Subject: Response To Application Number R/205/19/PD at 66 The Street Littlehampton BN16 3NR

WEST SUSSEX COUNTY COUNCIL CONSULTATION

TO:	Arun District Council FAO:Andrew Wood
FROM:	WSCC - Highways Authority
DATE:	11 October 2019
LOCATION:	66 The Street Littlehampton BN16 3NR
SUBJECT:	R/205/19/PD Notification for Prior Approval under Class PA for change of use from Premises in Light Industrial Use (Class B1(c)) to dwellinghouses (Class C3) to provide self contained flats (4 one bed flats & 2 two bed flats).
DATE OF SITE VISIT:	n/a
RECOMMENDATION:	More Information
S106 CONTRIBUTION TOTAL:	n/a

Drawing title: Proposed Plans

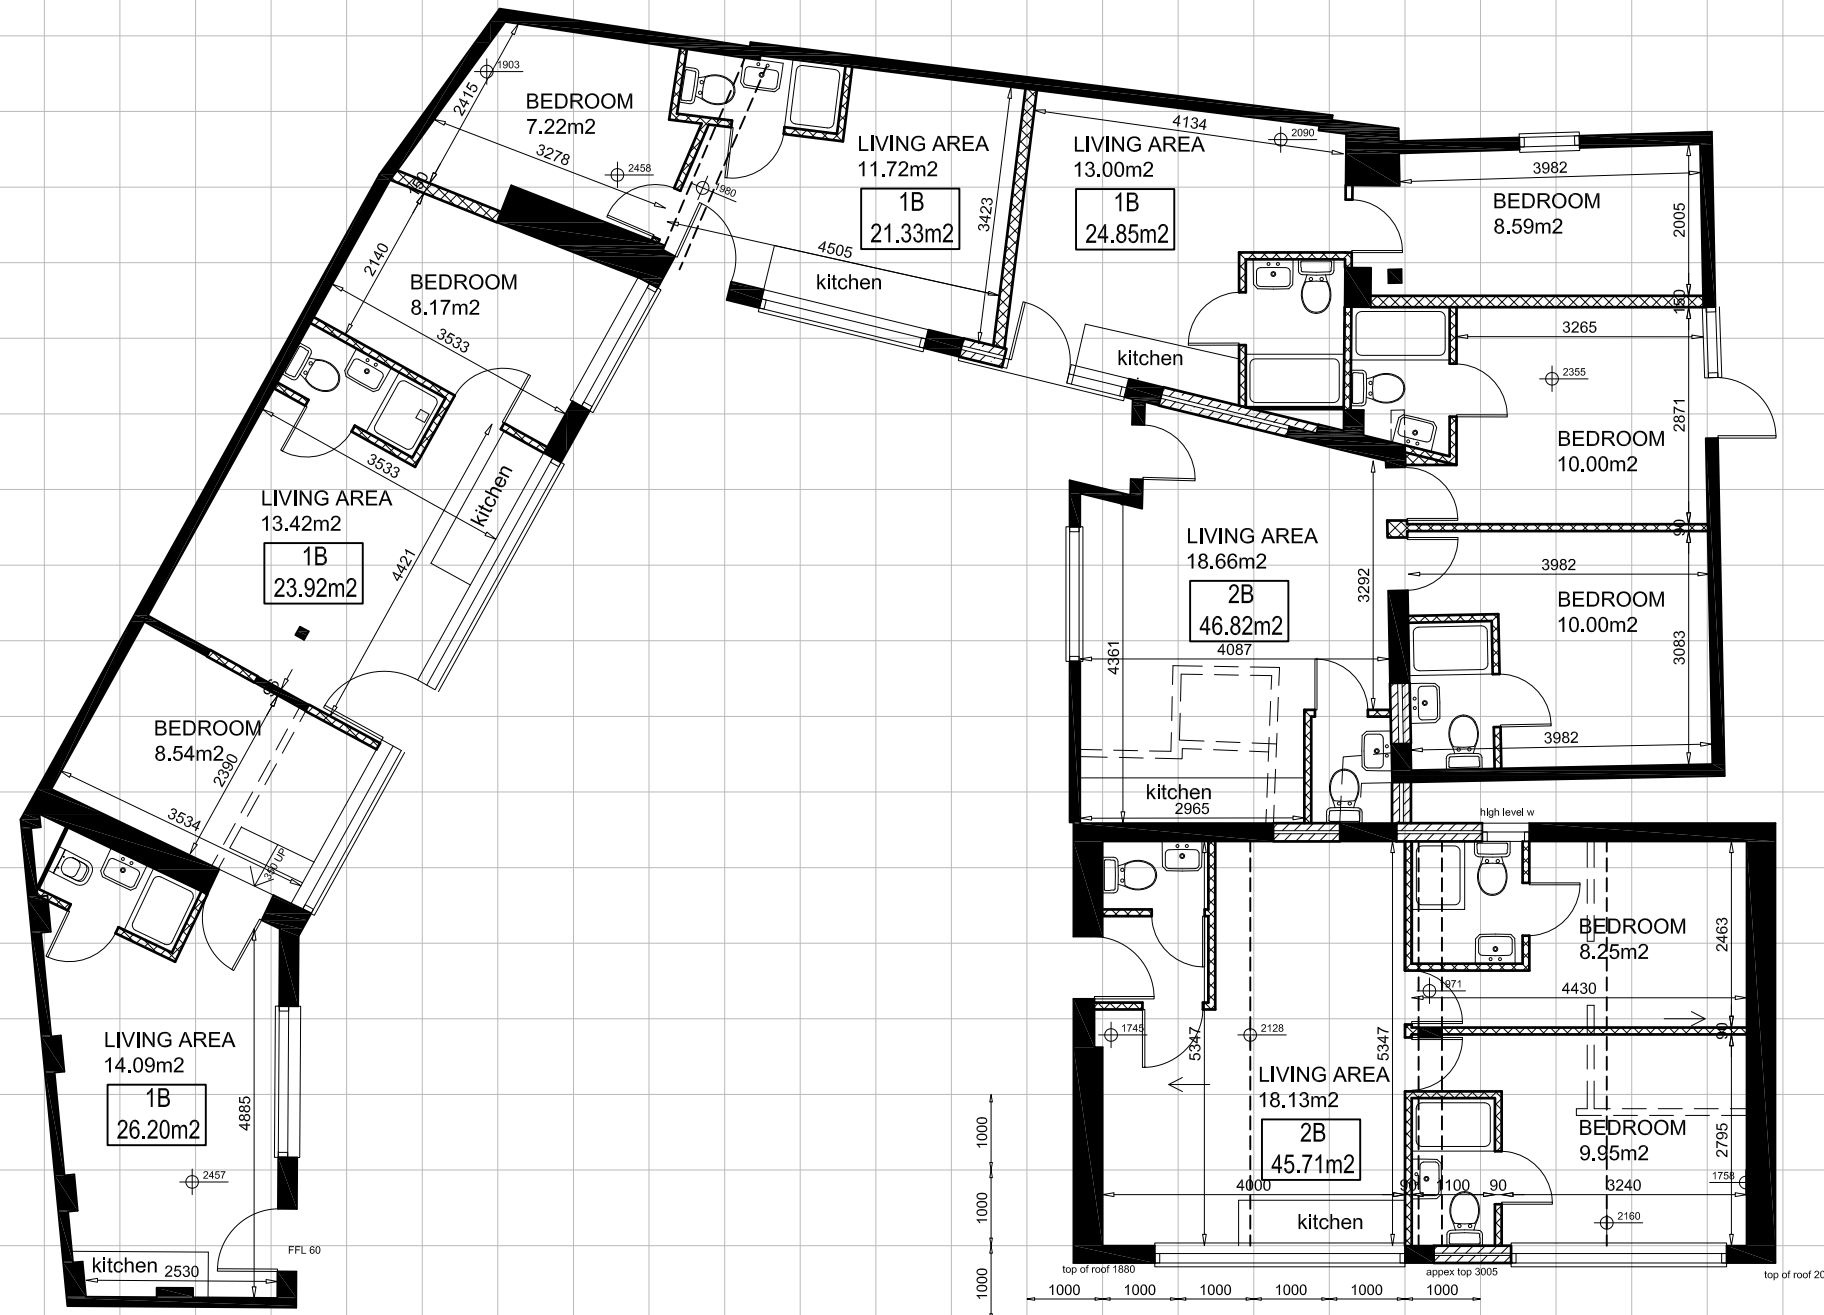
The Local Highway Authority requests additional information pertaining to the parking arrangements, as set out below.

Transport report states that parking provision of 6 spaces can be accommodated onsite. These spaces have not been demonstrated on the proposed plans. Our mapping shows that the internal area (within the red edge of the block plan) has insufficient space to accommodate 6 parking spaces. Therefore, the applicant is requested to provide details of the maximum parking spaces that can be accommodated onsite and any allocation to units that that will provided. This information is

required so that appropriate advice regarding parking, and any potential overspill parking, can be provided.
